City of Albuquerque Stormwater Construction Site Inspection Report

ESC File No.	K10E060	Project Name:	7200 Bluewater		
NPDES Id. No.	NMR1003UT	Location:	7200 Bluewater		
2/28/2022	Owner	Contractor			
Operator	M & B Investments Ltd. Co.	GA Brunacini Construction			
Contact name & title	Angelo Brunacini	Angelo Brunacini			
e-mail	abrunacini@brunacini.com	abrunacini@brunacini.com			
Contact Phone #	505-833-2928	505-833-2928			
COA Inspector	Doug Hughes	Start/End Time:	3pm		
Construction Phase:	Earthwork				
Type of Inspection:	<input checked="" type="checkbox"/> Regular	<input type="checkbox"/> Storm Event	<input type="checkbox"/> Past Storm Event >0.25"	<input type="checkbox"/> 311/Complaint	<input type="checkbox"/> Follow Up
Weather at time of inspection?		clear		Temperature: ~	60
Estimated date of last storm 0.25" or greater		1/1/2022

SWPPP INFORMATION SIGN
N.T.S. (SS)

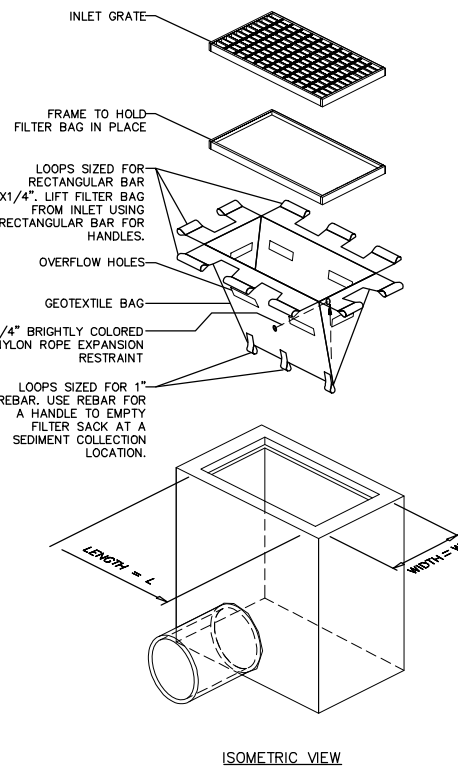
Item Number	Deficiency/ Corrective Action				
1	Permit coverage was not properly posted, dsign was laying on the ground but still ledgible.				
2	Minor washout next to the container needs disposed in the waste container.				
3					
4					
5
